Zoning Board of Appeals meeting tonight

I am writing about the Zoning Board of Appeals hearing tonight concerning the proposed change at the Grace Baptist Church and the proposed ice canopy.

SHEET TITLE
COMPOUND PLAN

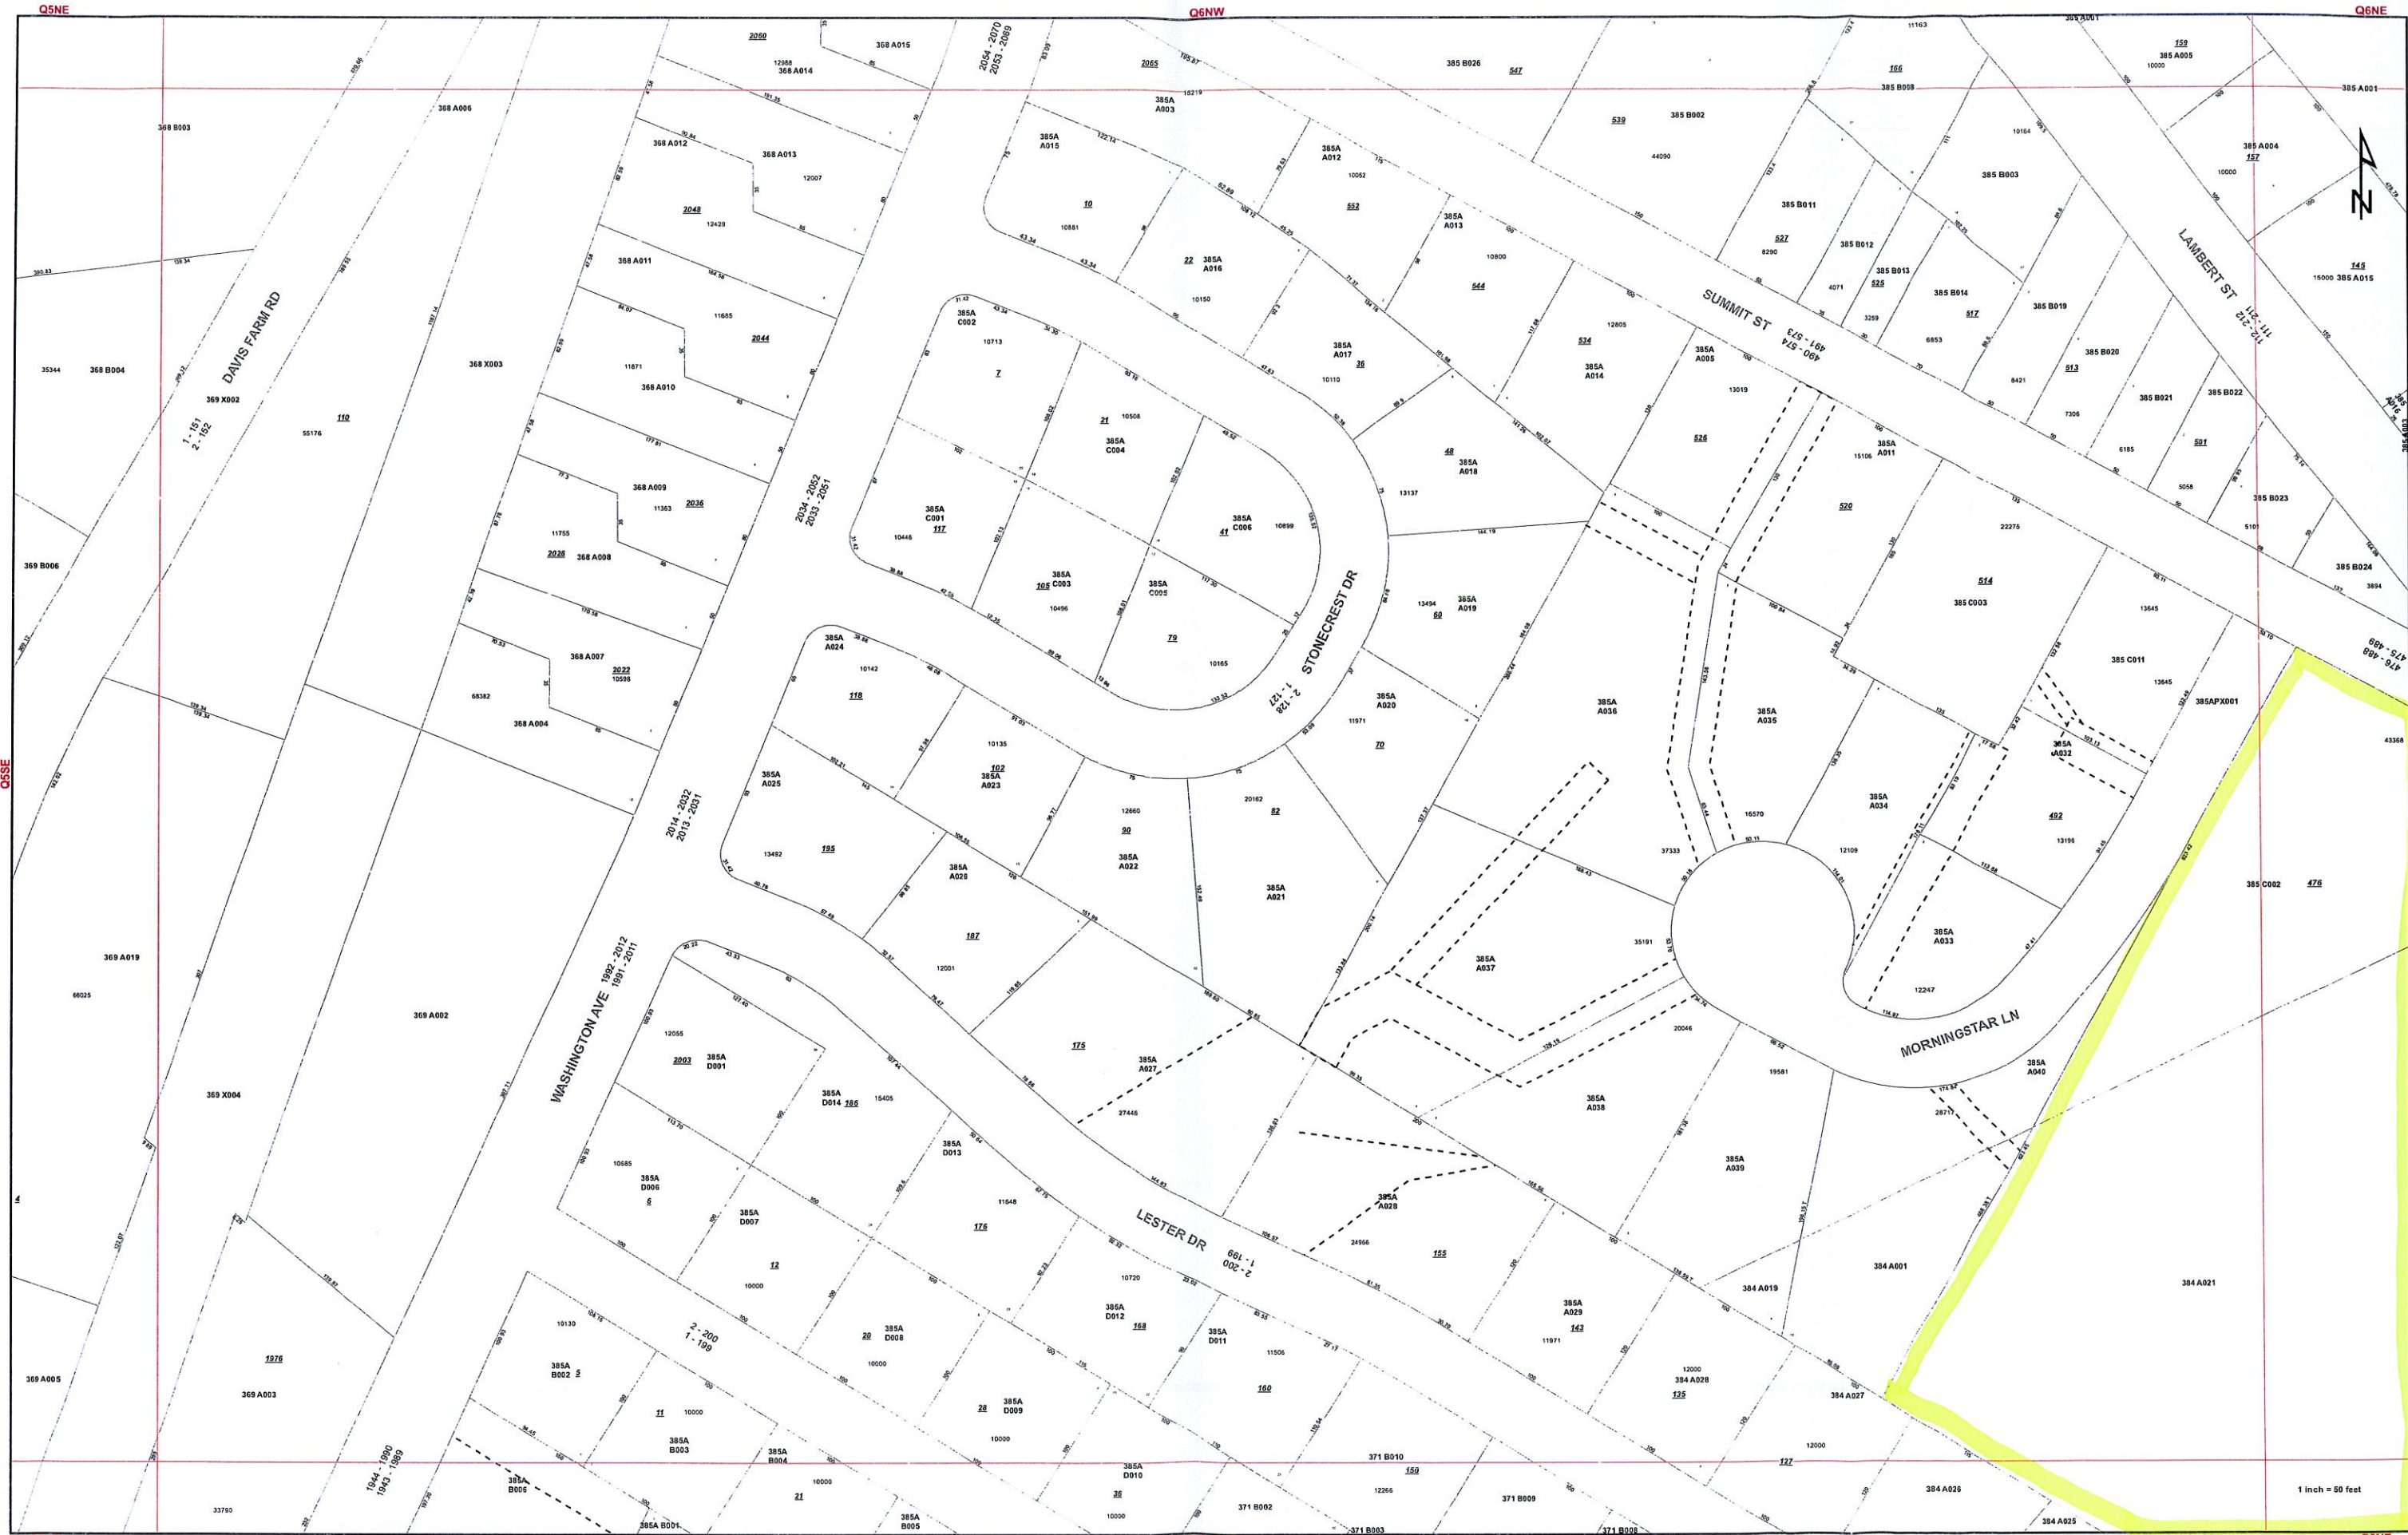
If the generator is going to be used only for emergency power interruptions then I would not strongly oppose the change from a shed to a shelter.

However, if the generator is going to be running 24 x 7 to power the wireless tower then I would strongly object to replacing an enclosed shed with a generator on a pad in the open.

The equipment shelter was approved in the original application and Verizon should have to abide by that initial decision and not be allowed to change to

an open generator on a pad.
